Planning Application No: 3/2026/0500

Proposal: Retrospective application for the erection of a concrete walled structure for a agricultural silo clamp.

Location: Wheatley Farm, Four Acre Lane, Thornley PR3 2TD

Having reviewed the documents submitted Lancashire County Council acting as the highway authority makes the following initial comments and requests further information/clarification.

TITLE
OS Map & Block Plan

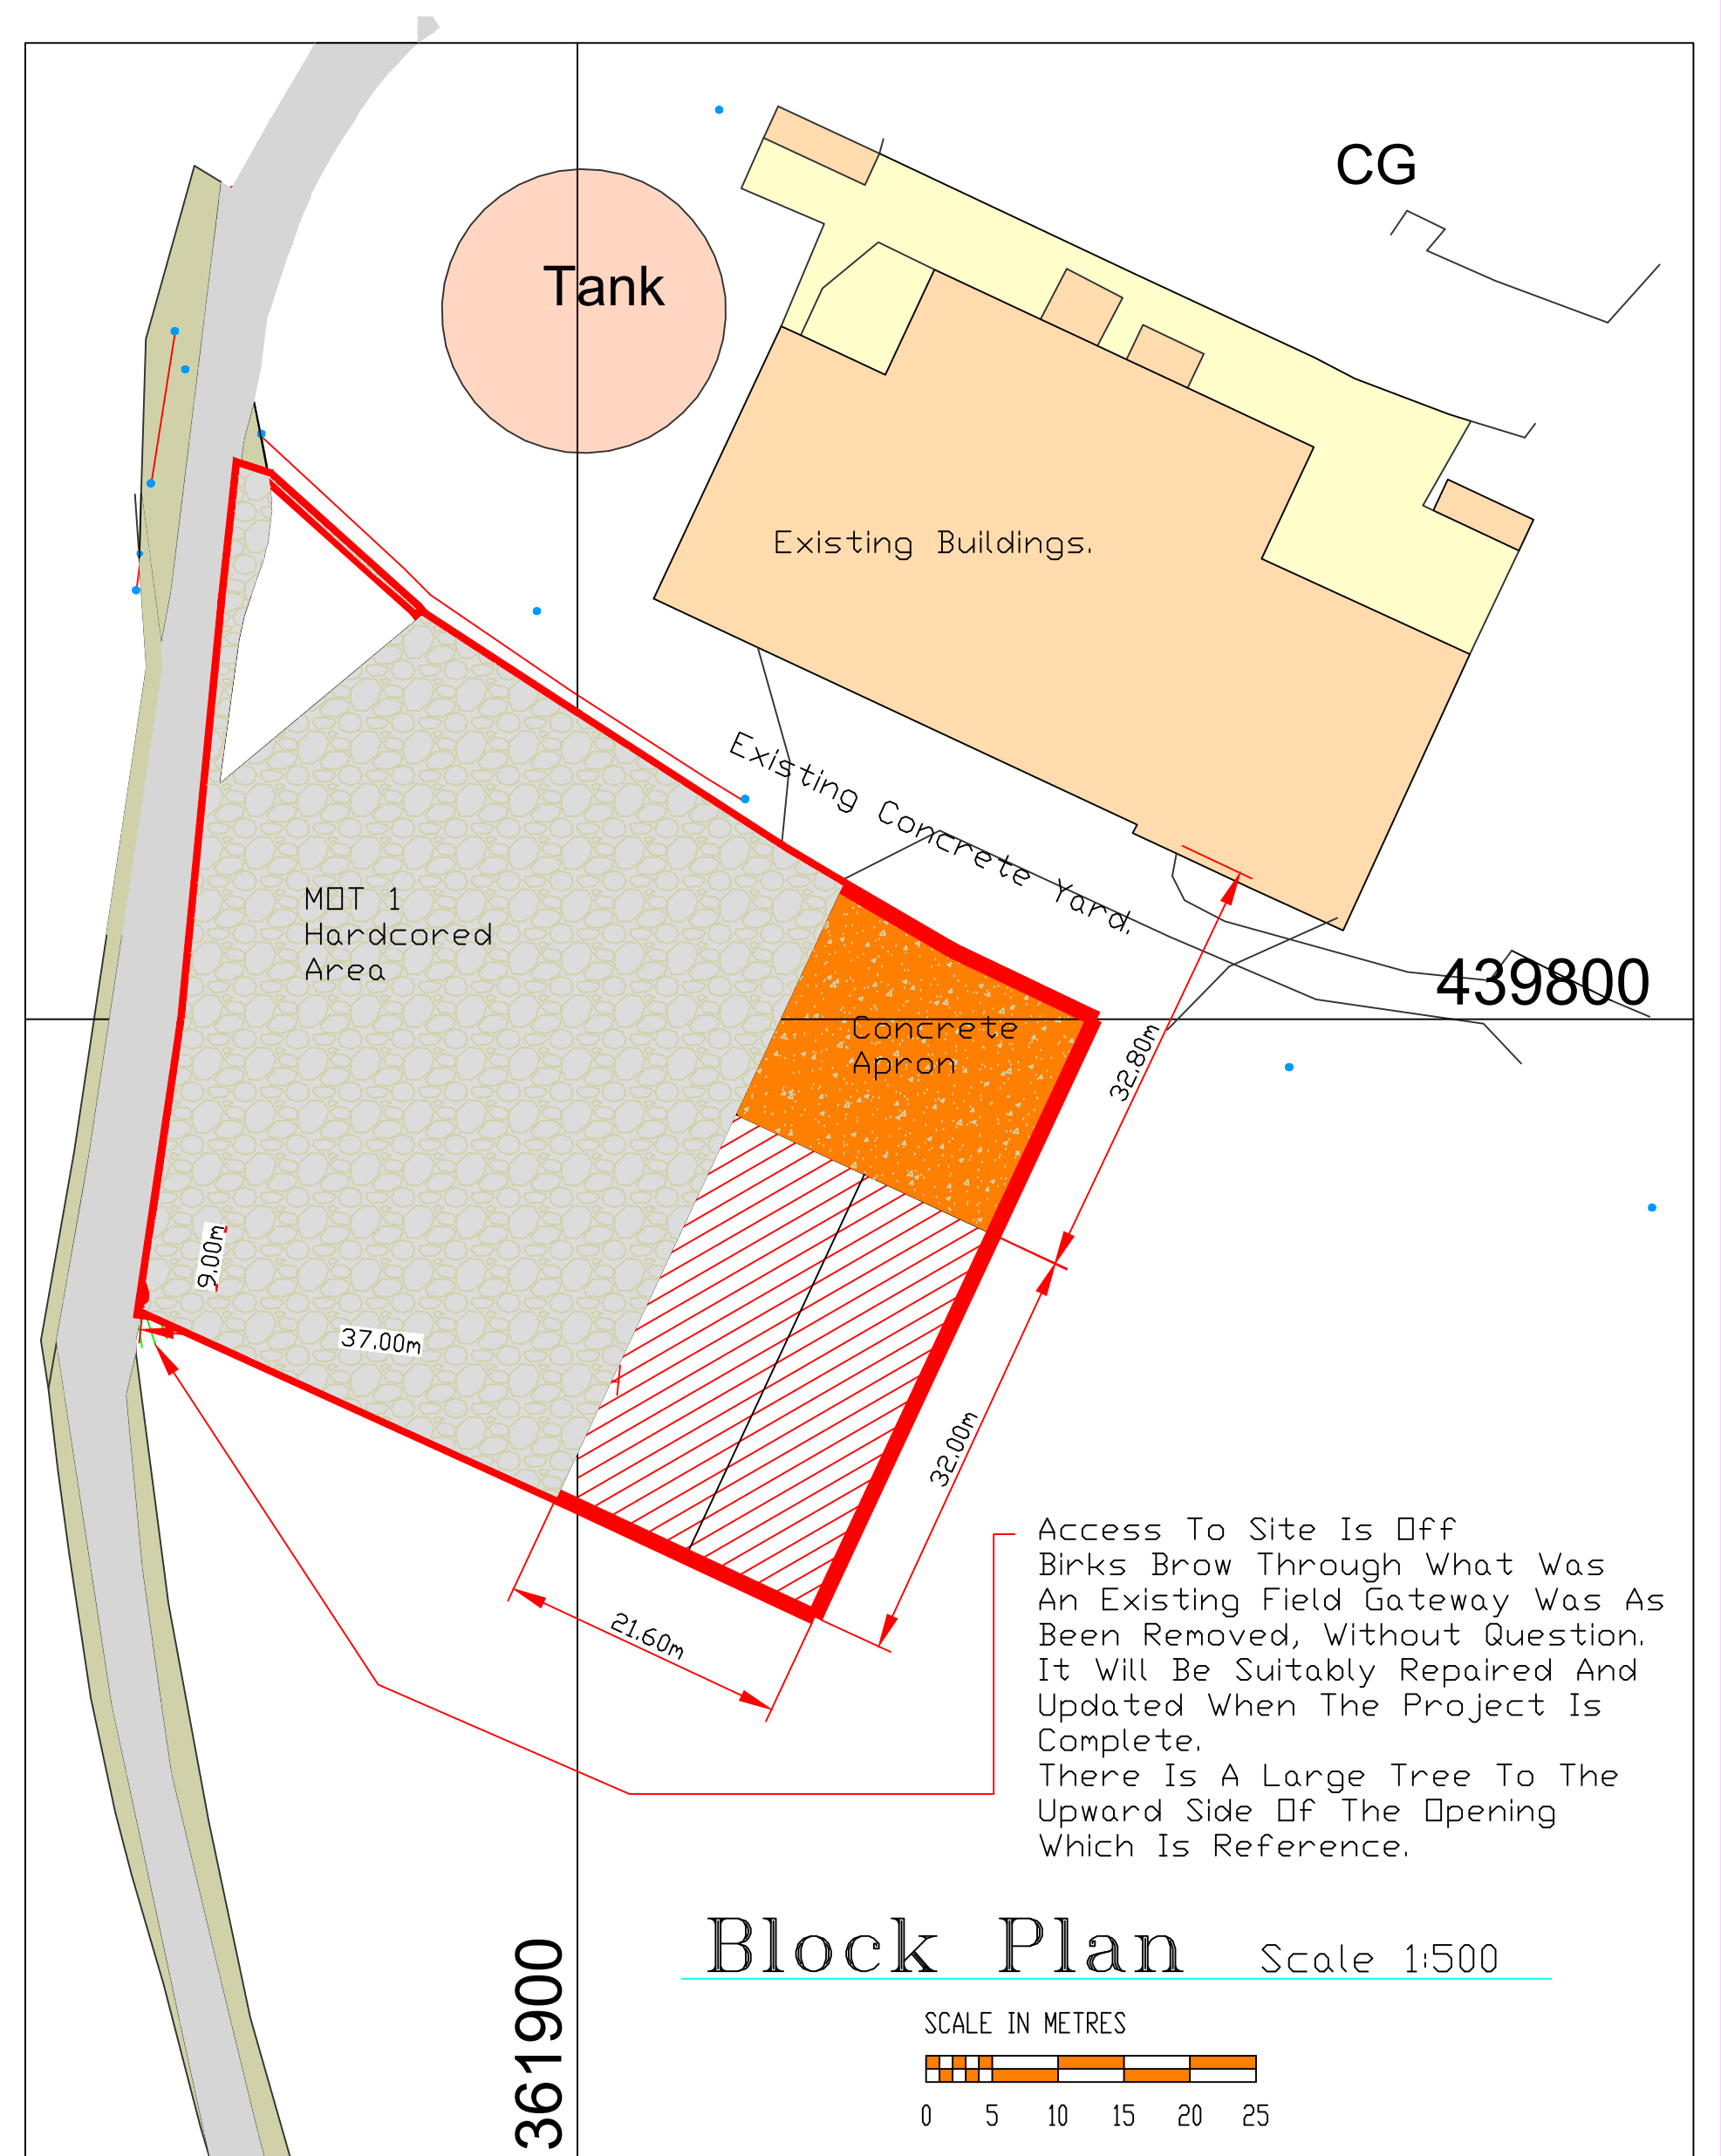
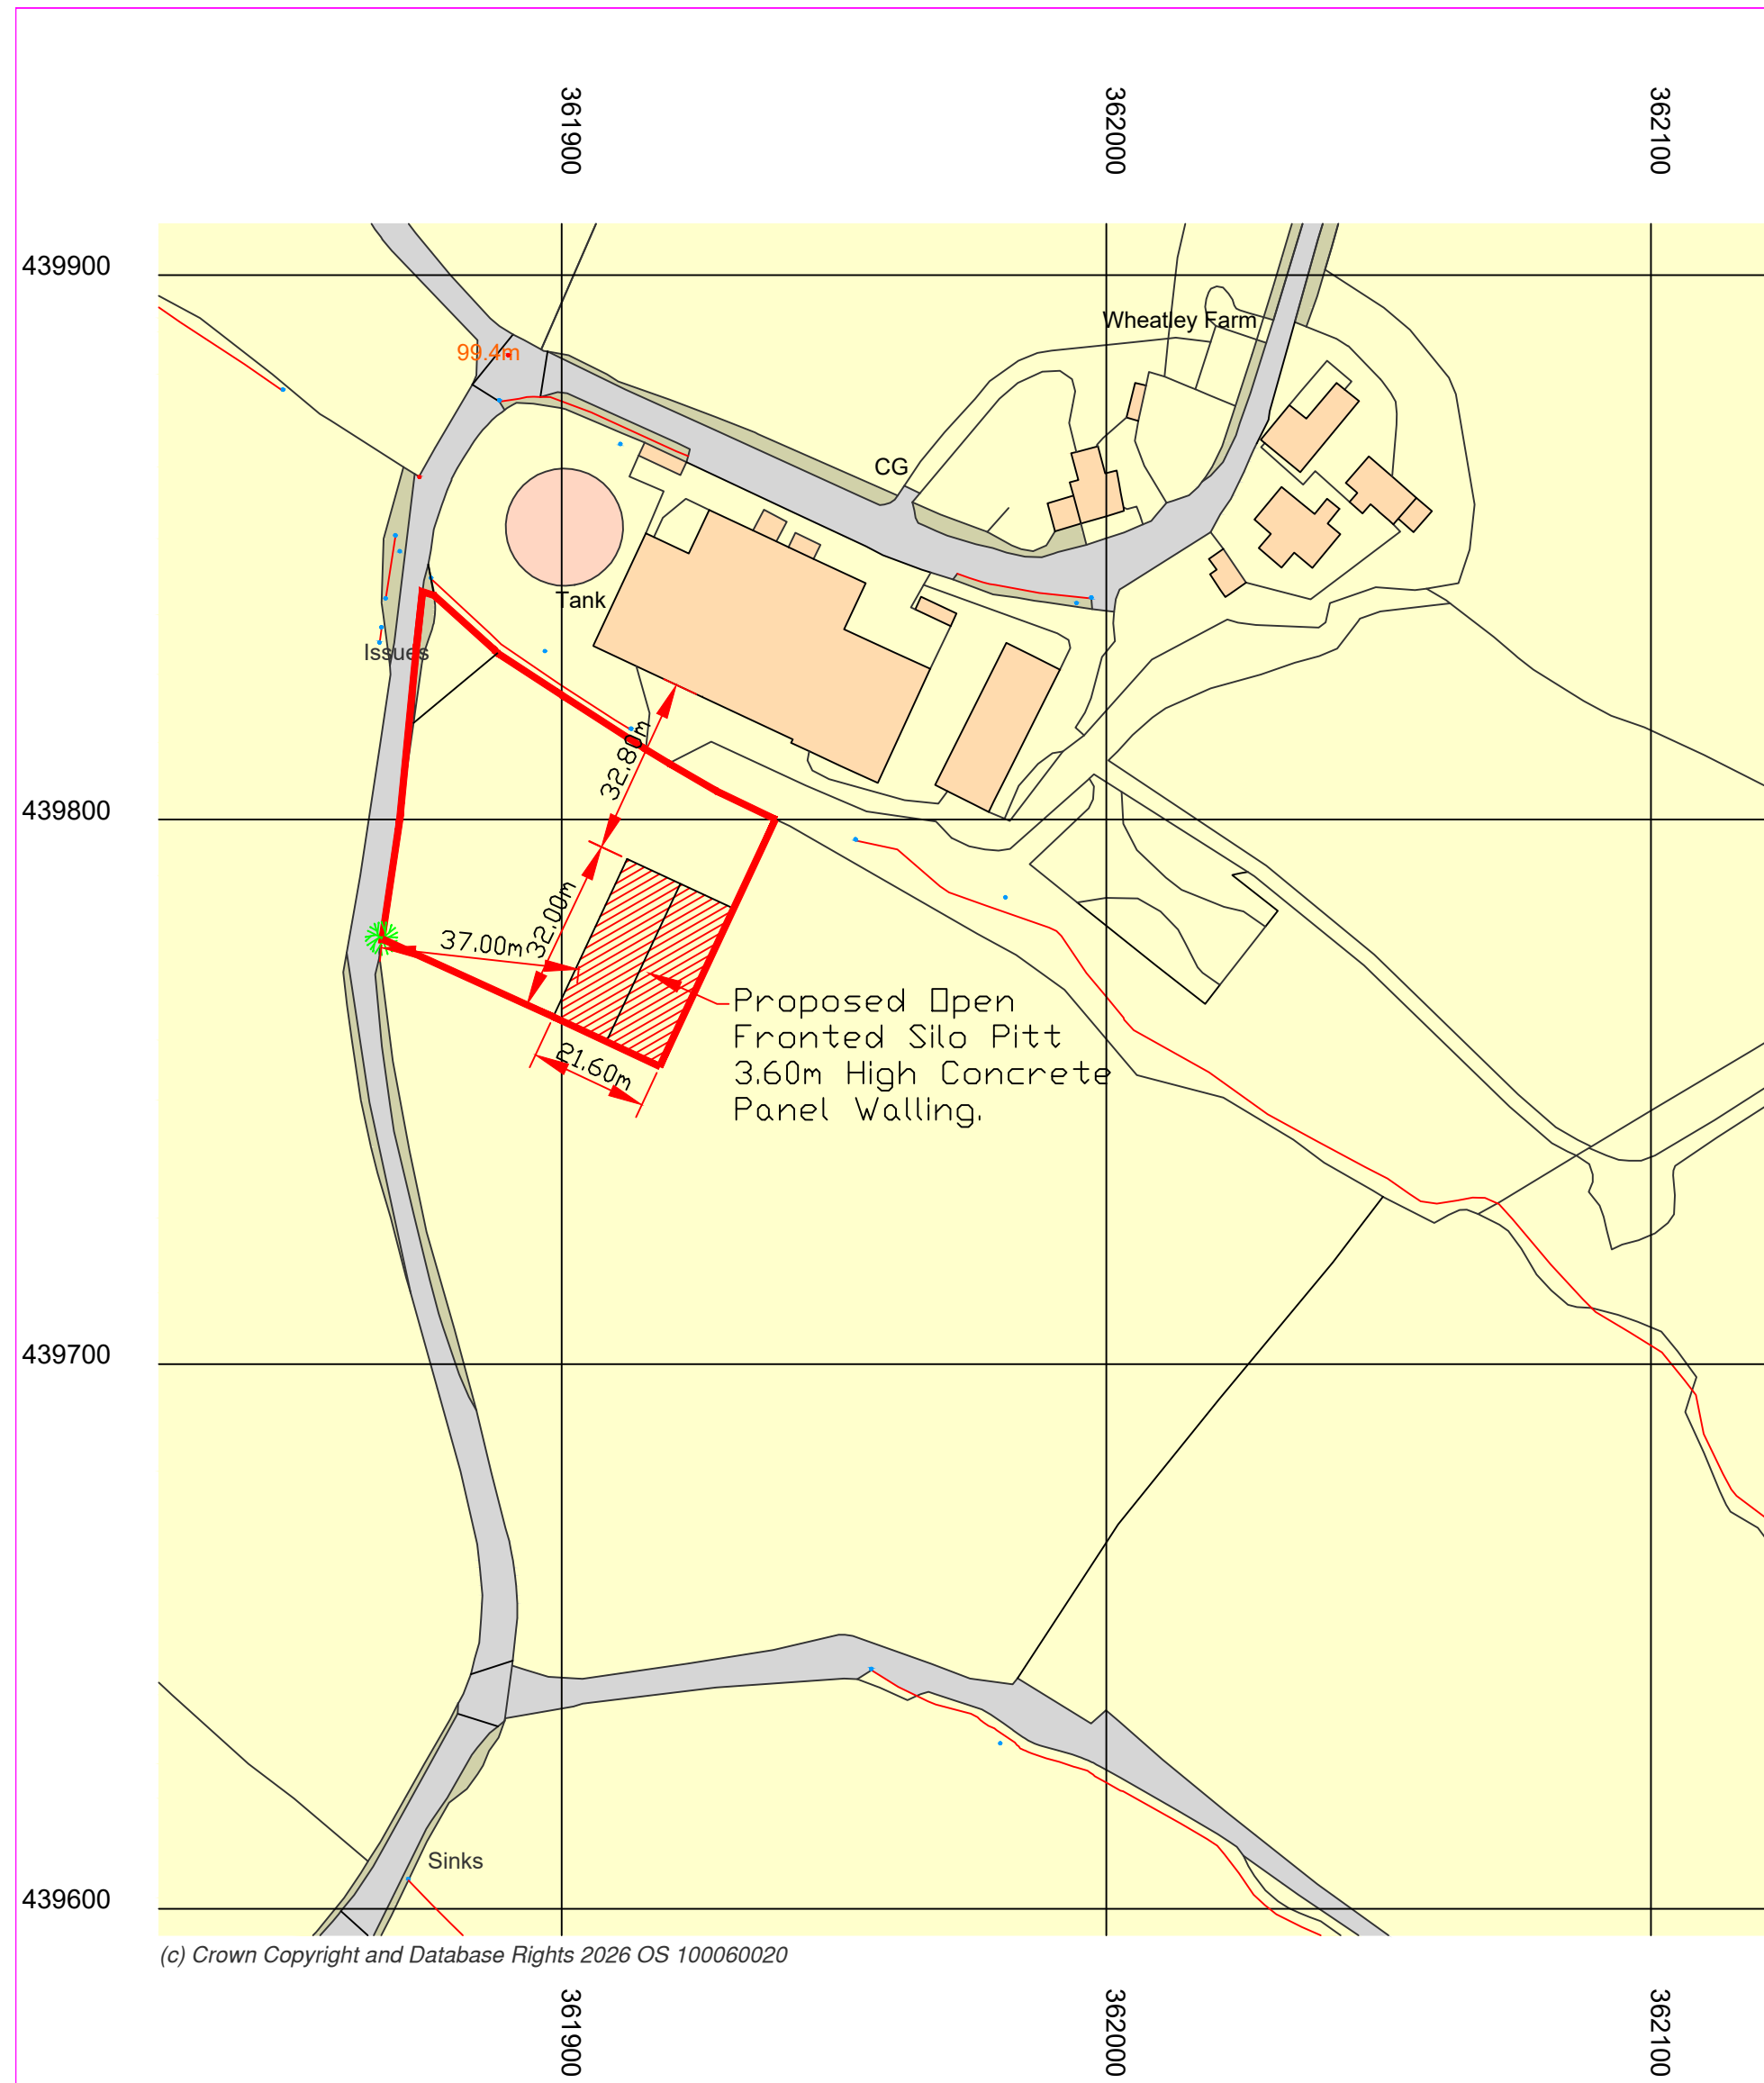
Access to the site is taken off Birks Brow. There was previously a field gate, but a section of hedgerow has been removed, and the access substantially widened, although a properly constructed access has not been provided. The area between Birks Brow and the silage clamp is shown to be surfaced in hardcore.

- The authority needs to know precisely what the access onto Birks Brow will be used for to be able to advise an appropriate reinstatement scheme for the site access. The widened access will need to be properly constructed to tie into the carriageway edge on Birks Brow, the first 10m into the site will need to be surfaced in a bound material and not hardcore, and surface water will need to be collected across the front of this area of bound material and drained to a suitable internal outfall to prevent water from discharging onto Birks Brow.

- Any re-instated access onto Birks Brow needs to be located centrally to maximise the visibility splays. These will need to be demonstrated for the posted road speed limit of 60mph, which is 215m splays in both directions. However, given the road layout traffic may be travelling below the maximum speed limit, and shorter visibility splays may be accepted. However these would need to be supported through data obtained by an automated seven day survey carried out in a neutral month, avoiding school holidays, national holidays and events, or local events which could impact on traffic movements and with prevailing weather conditions noted.

The highway authority notes that a track has been constructed across the field leading from the widened access off Birks Brow. The authority has been unable to find any planning permission for this. Given the planning history of the site and adjacent part of the wider field this raises concerns that the wider field/site will be further developed, leading to an intensification in the use of the site access.
